Response to Submissions Report

State Significant Development – SSD 18_9095

Armidale High School Redevelopment

Butler Street, Armidale

EXISTING

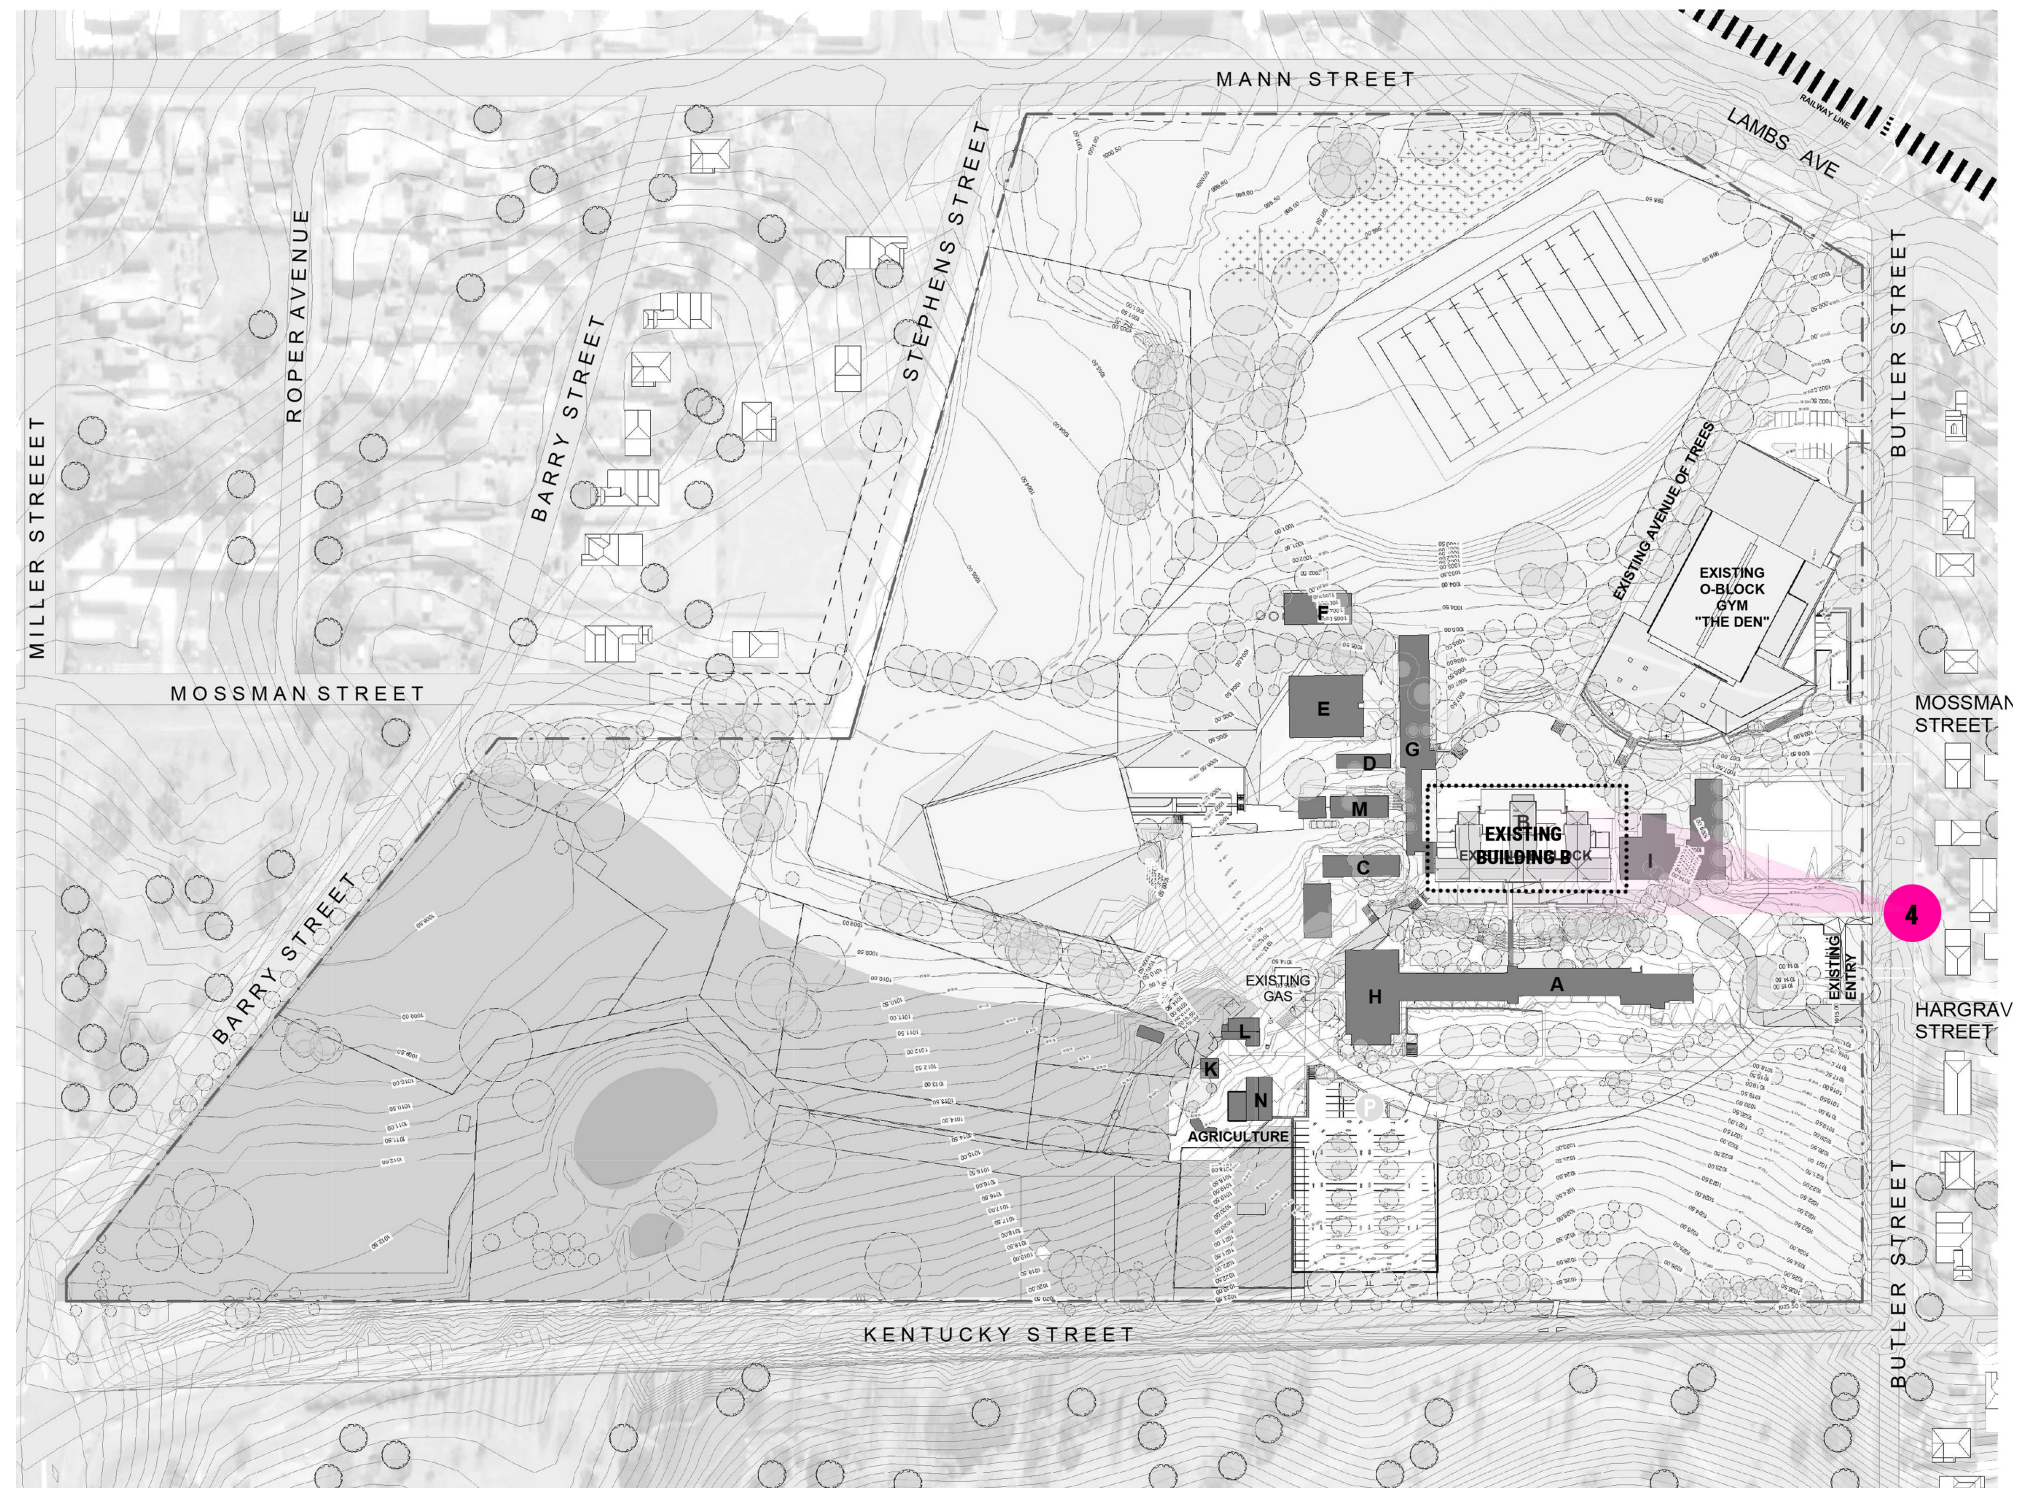
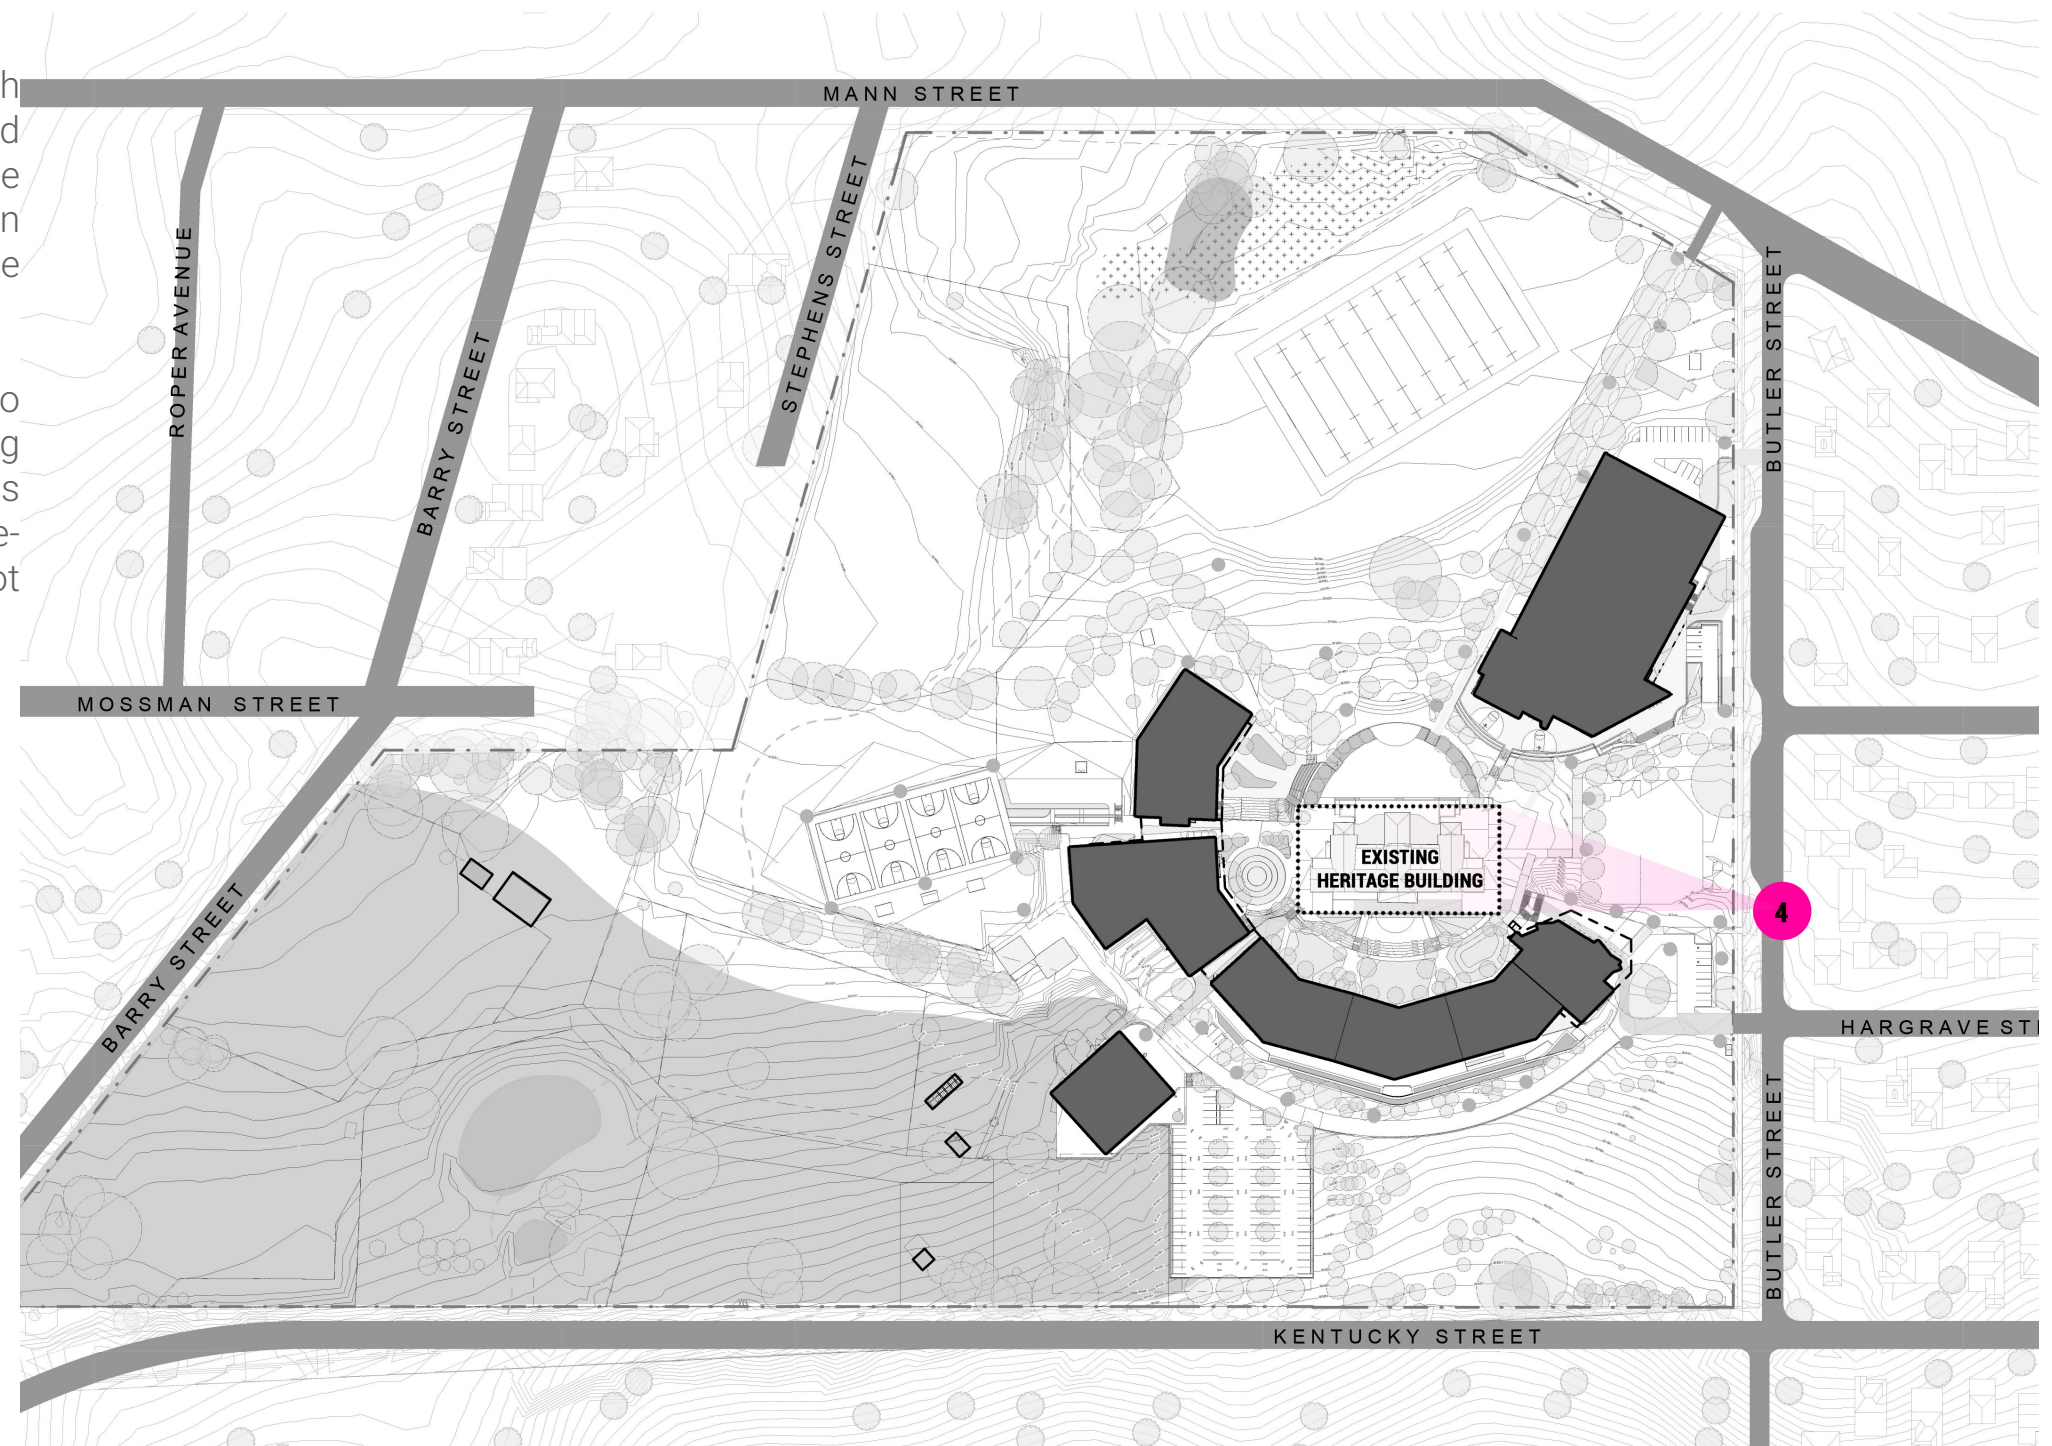
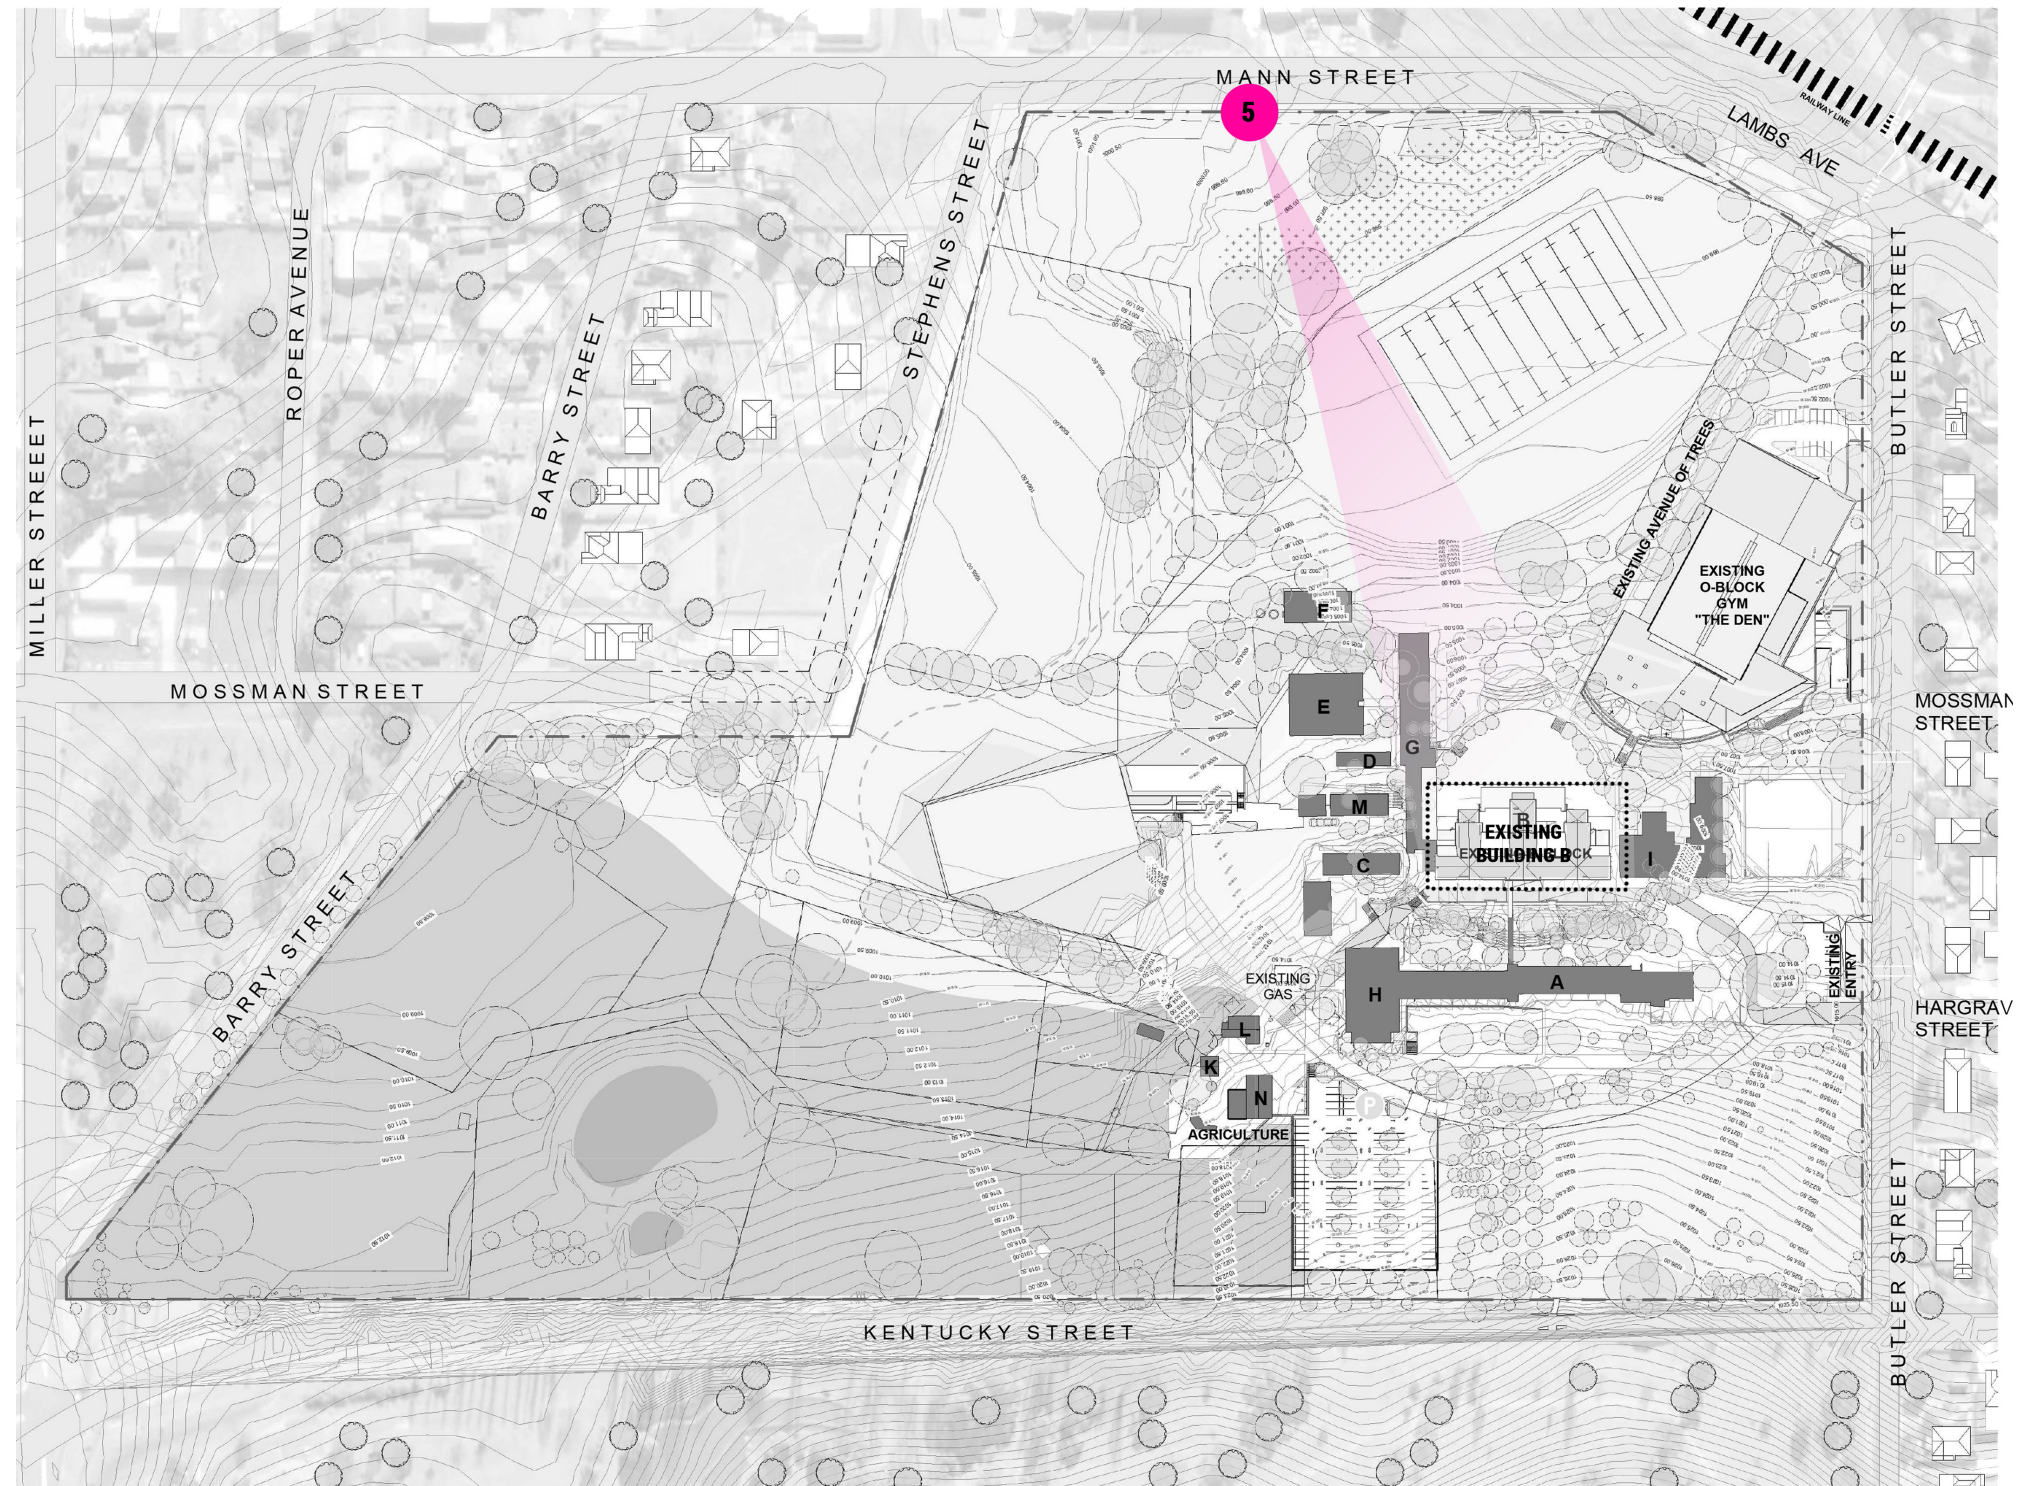
7. While it is acknowledged the Council did not raise concerns with regard to the proposed development, the Heritage Council has raised concern with regard to the impact of the proposal on significant views to the locally listed heritage item. Additional information is required addressing the impact of the proposal on the significant views.	The View Analysis provided as part of the original DA submission (refer Appendix 16 of the EIS) has been updated to provide additional information, including: - Comparison between existing and proposed views at significant viewpoints around the site; - Demonstration as to how these views would be maintained with the construction of the proposed buildings; and - Consideration of the impact the proposed buildings would have on significant views, including potential improvement to views or prominence of visual settings within the site. Further, it is noted that the design change to accommodate air conditioning (resulting in an increase in building height by 300mm) has been incorporated into the expanded View Analysis.	View Analysis Appendix 2
